EPC STORMWATER REVIEW COMMENTS ARE SHOWN IN ORANGE BOXES WITH BLACK TEXT

2022 Financial Assurance Estimate Form (with pre-plat construction) mulching should match seeding quantity

PROJECT INFORMATION		
D49 Transportation Center	6/15/2022	
Project Name	Date	PCD File No.

\\s456\Drawings\456-CE-ESP-01.dwg, 9/20/2022 - 5:21 PM, AMB

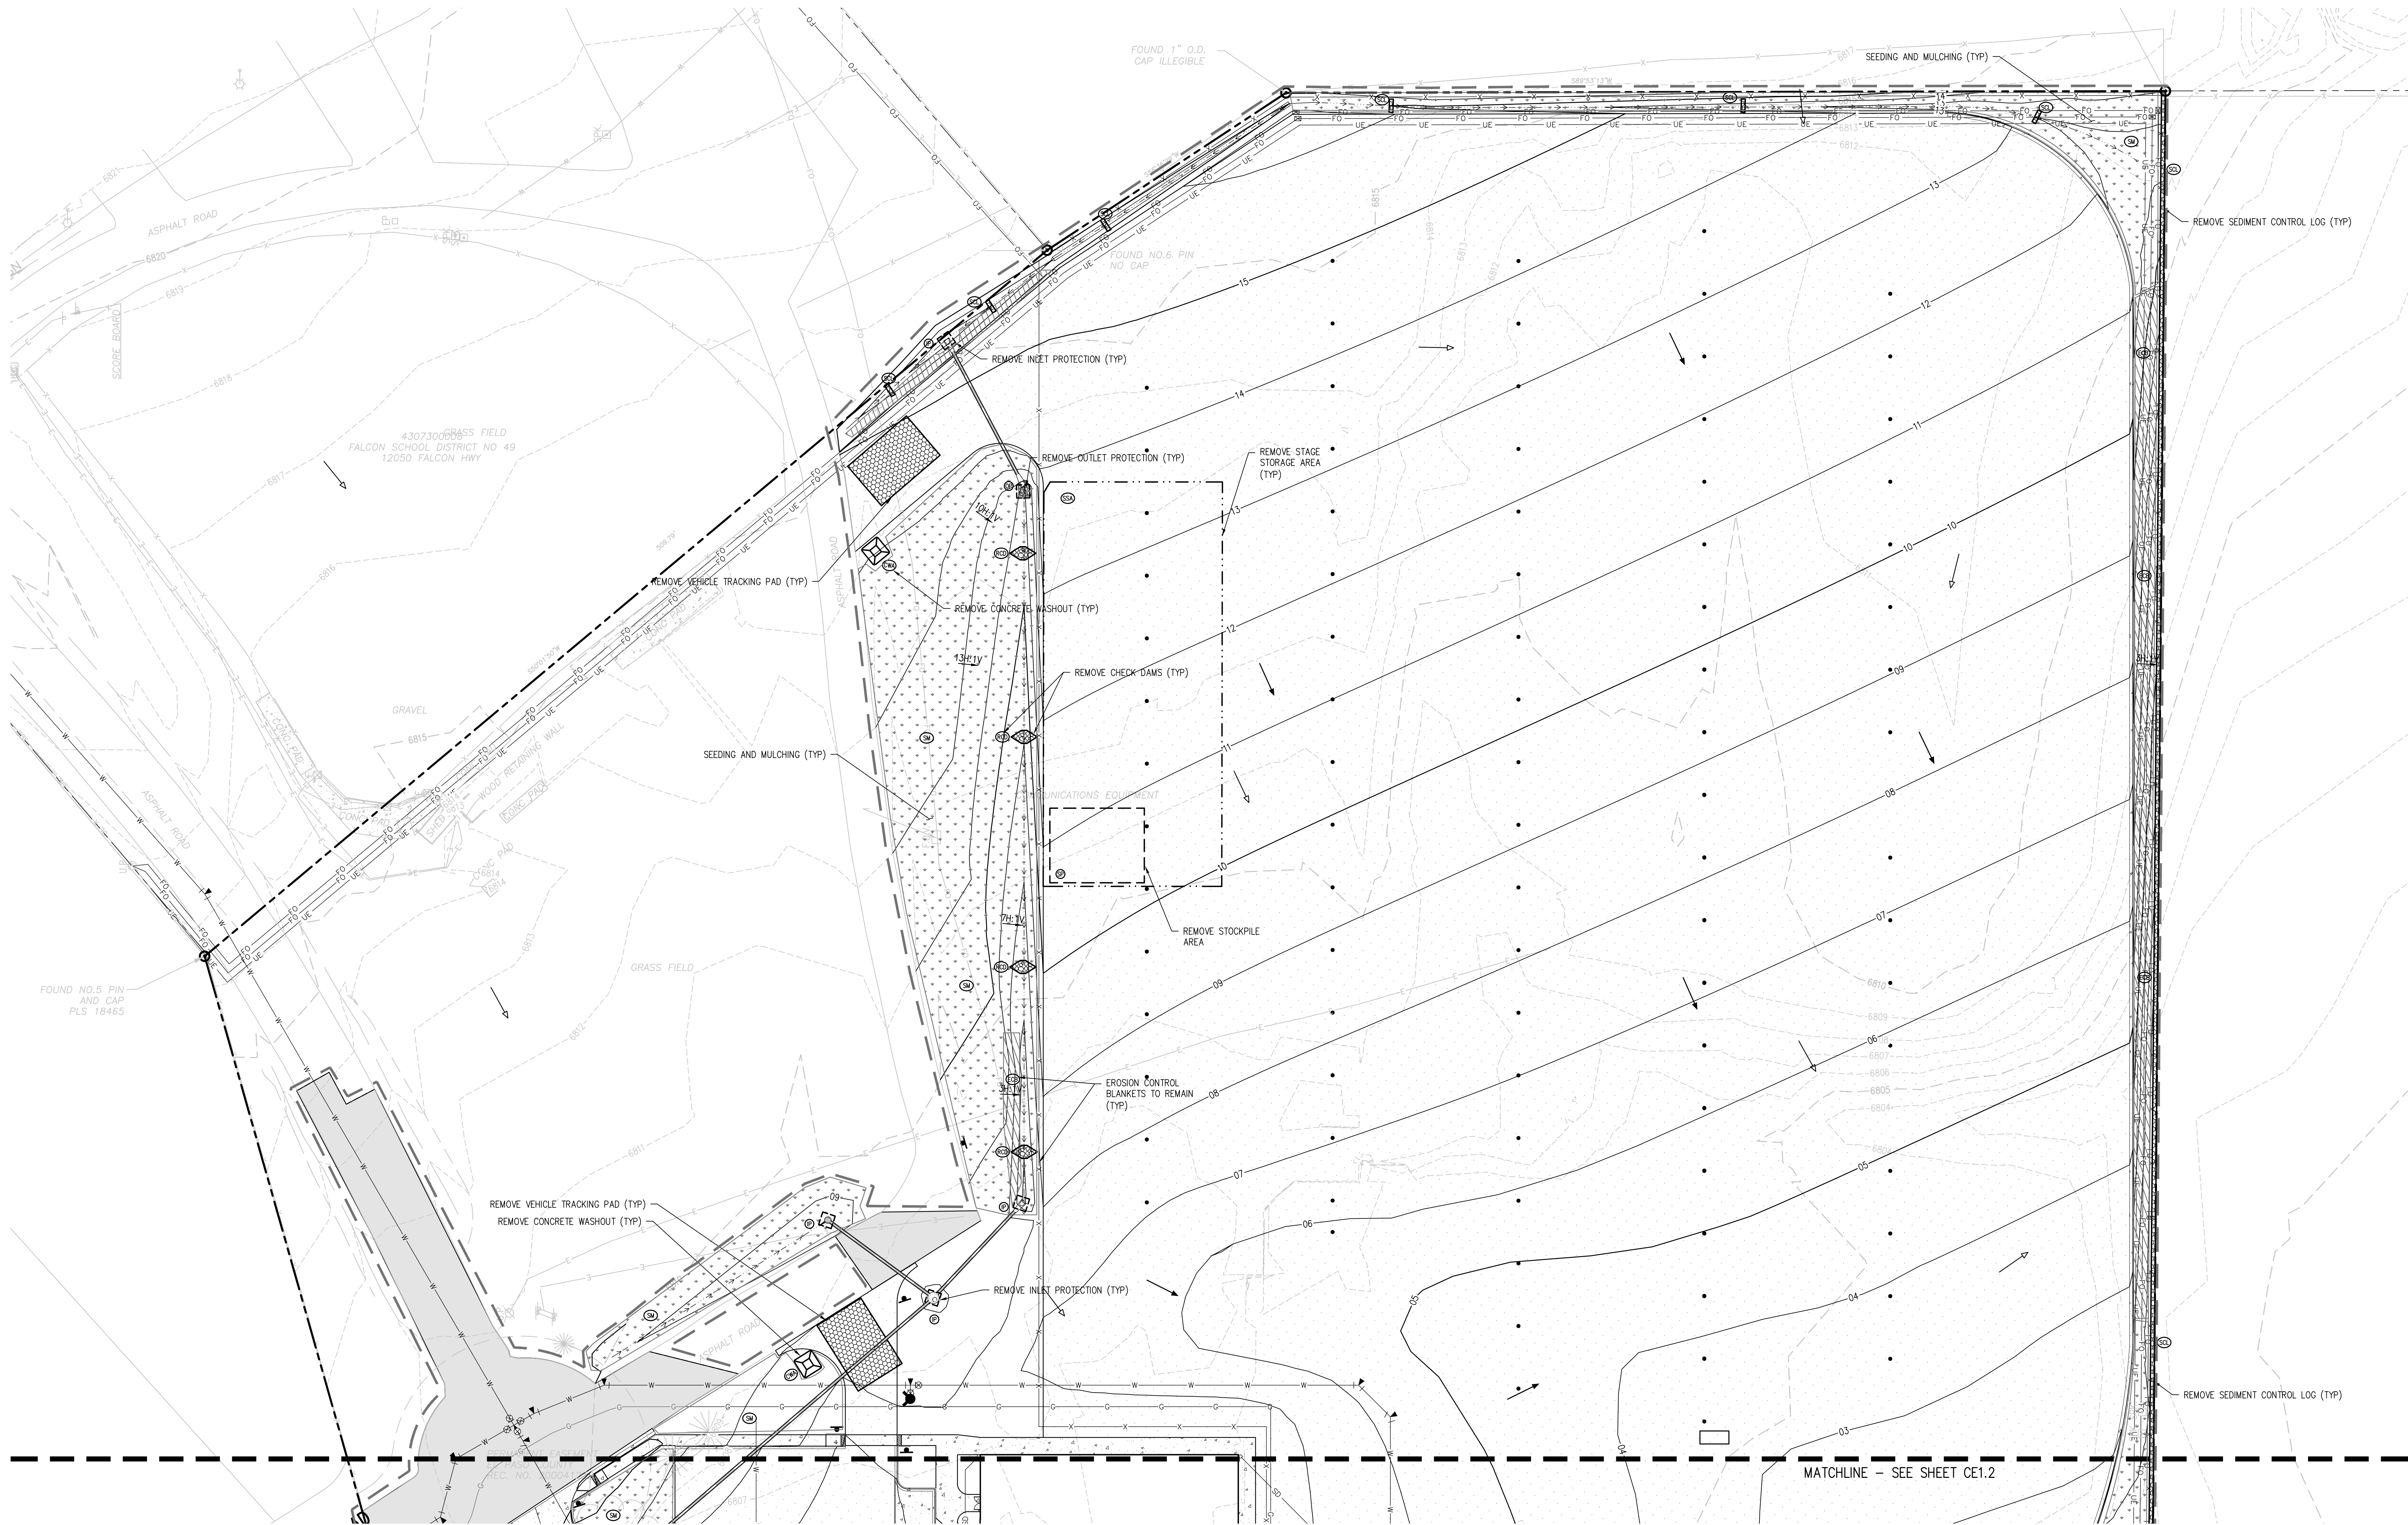
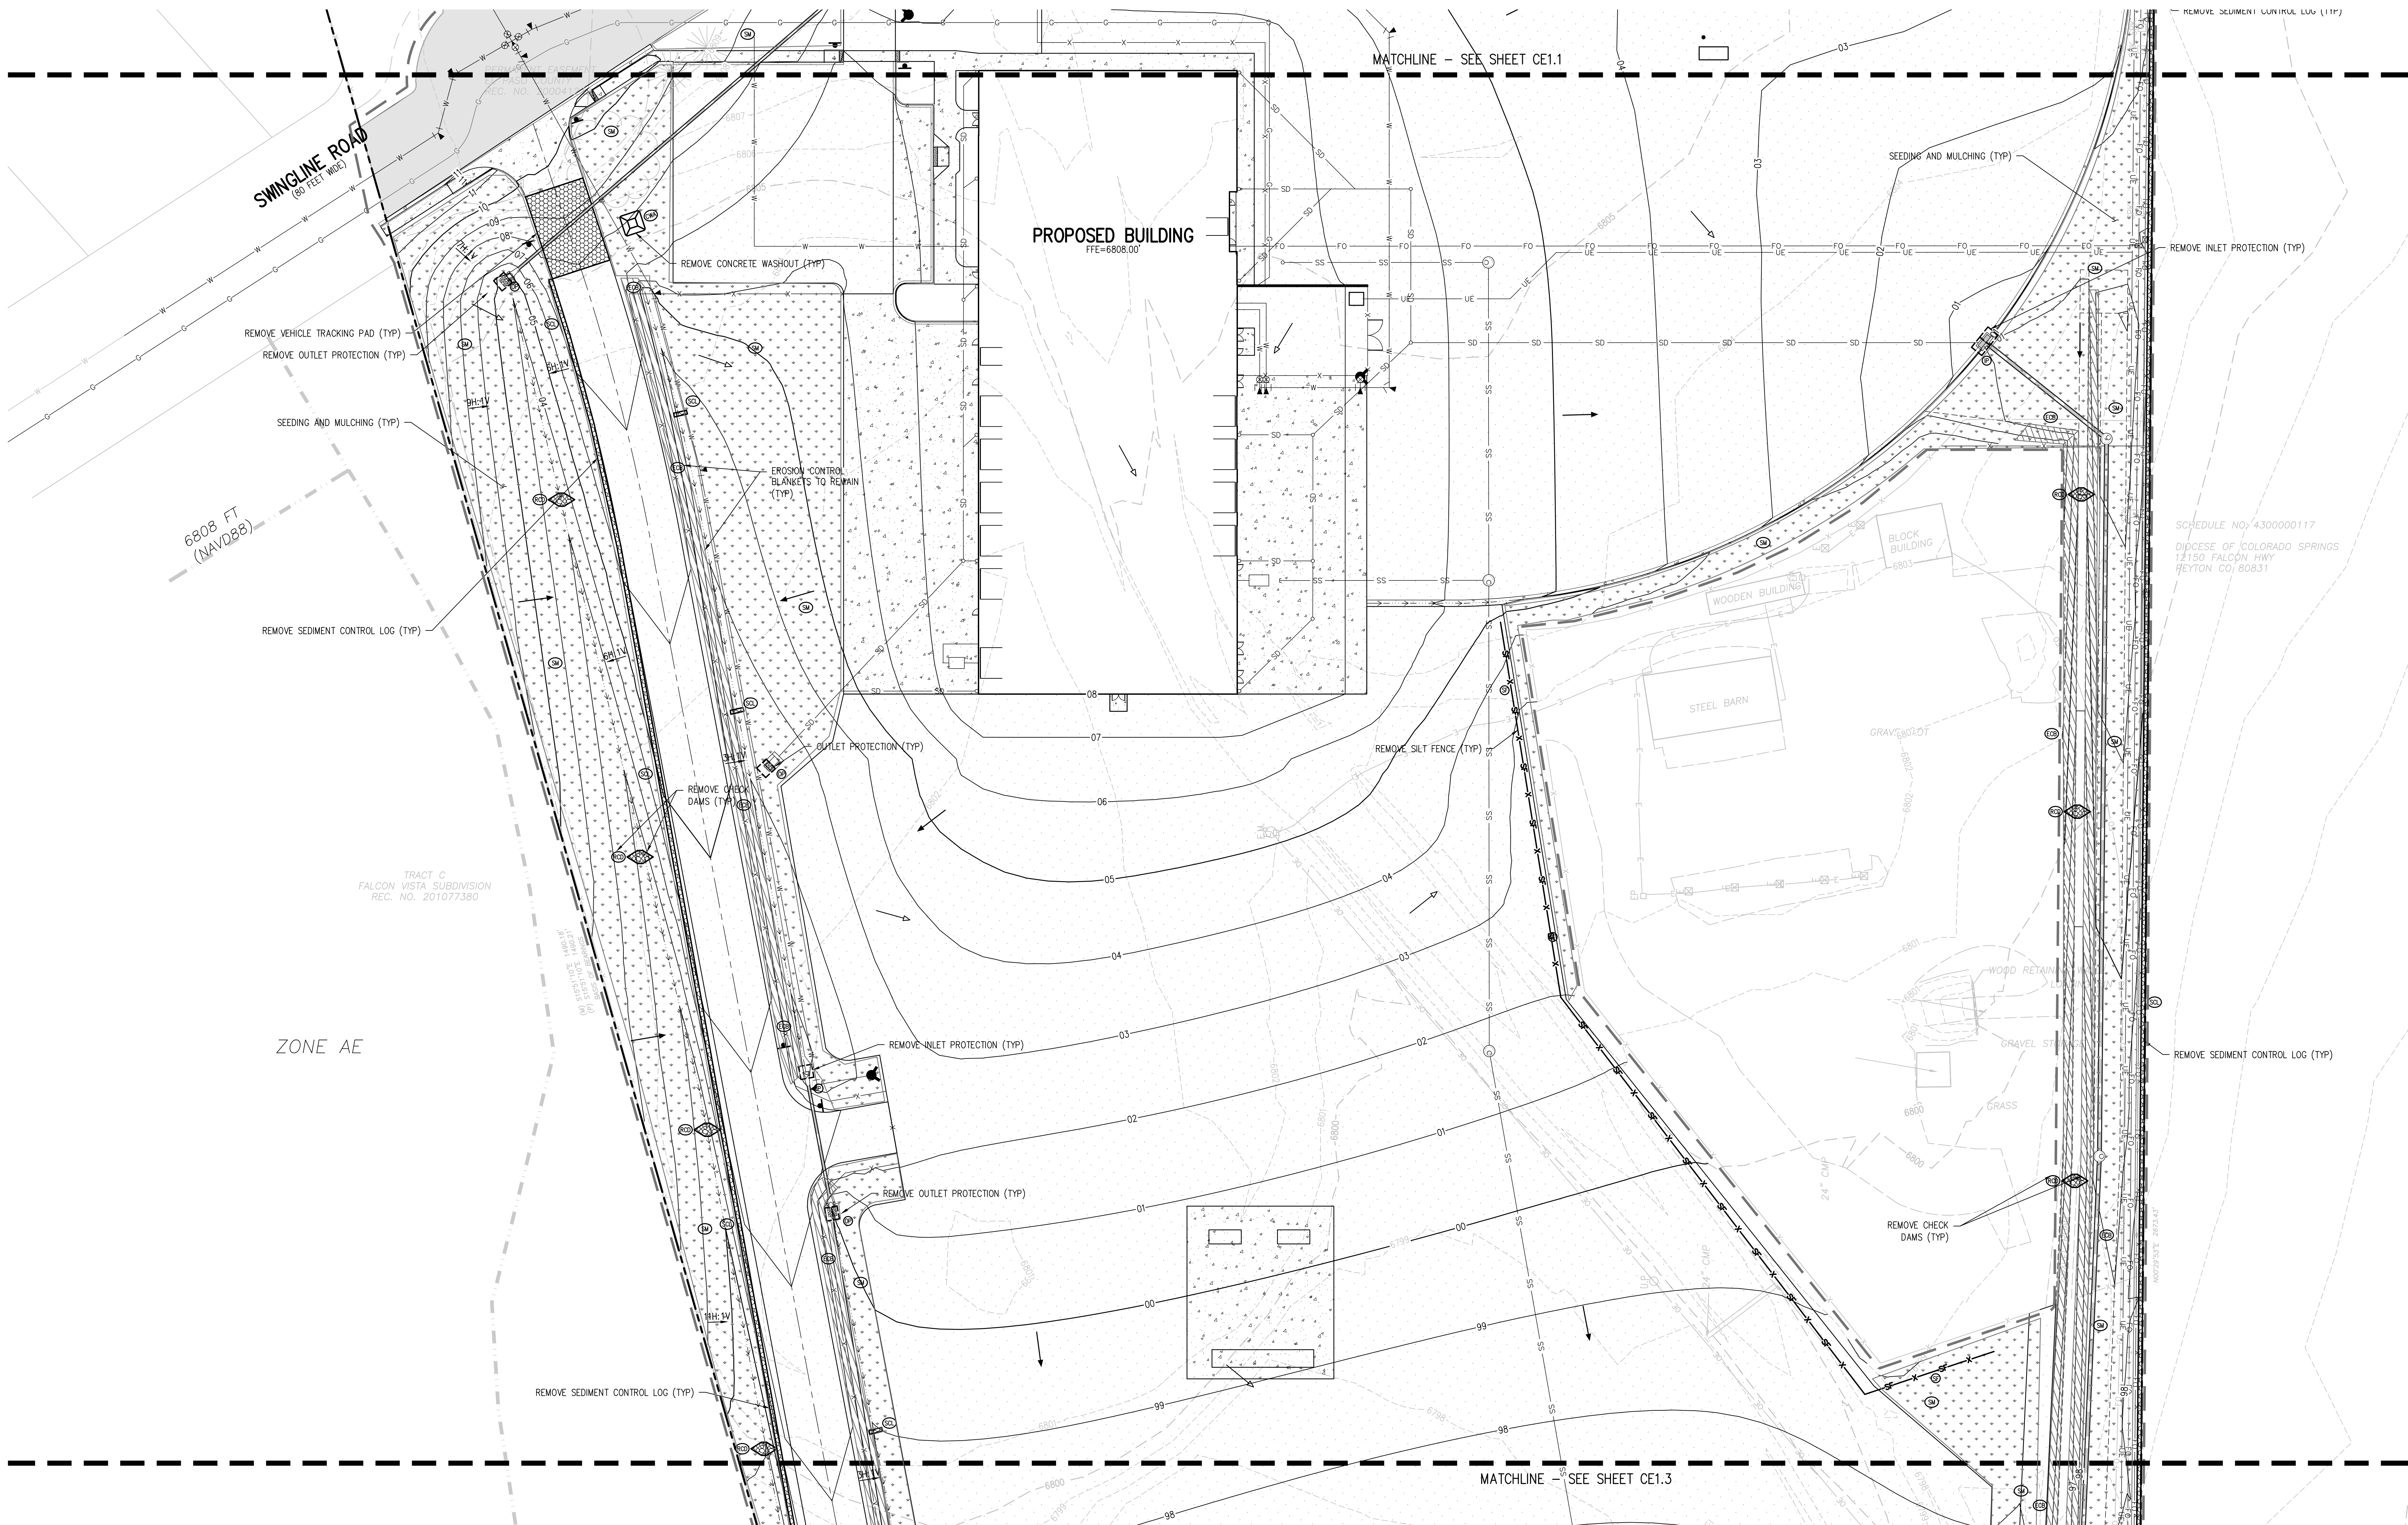
RCDs shown on figures
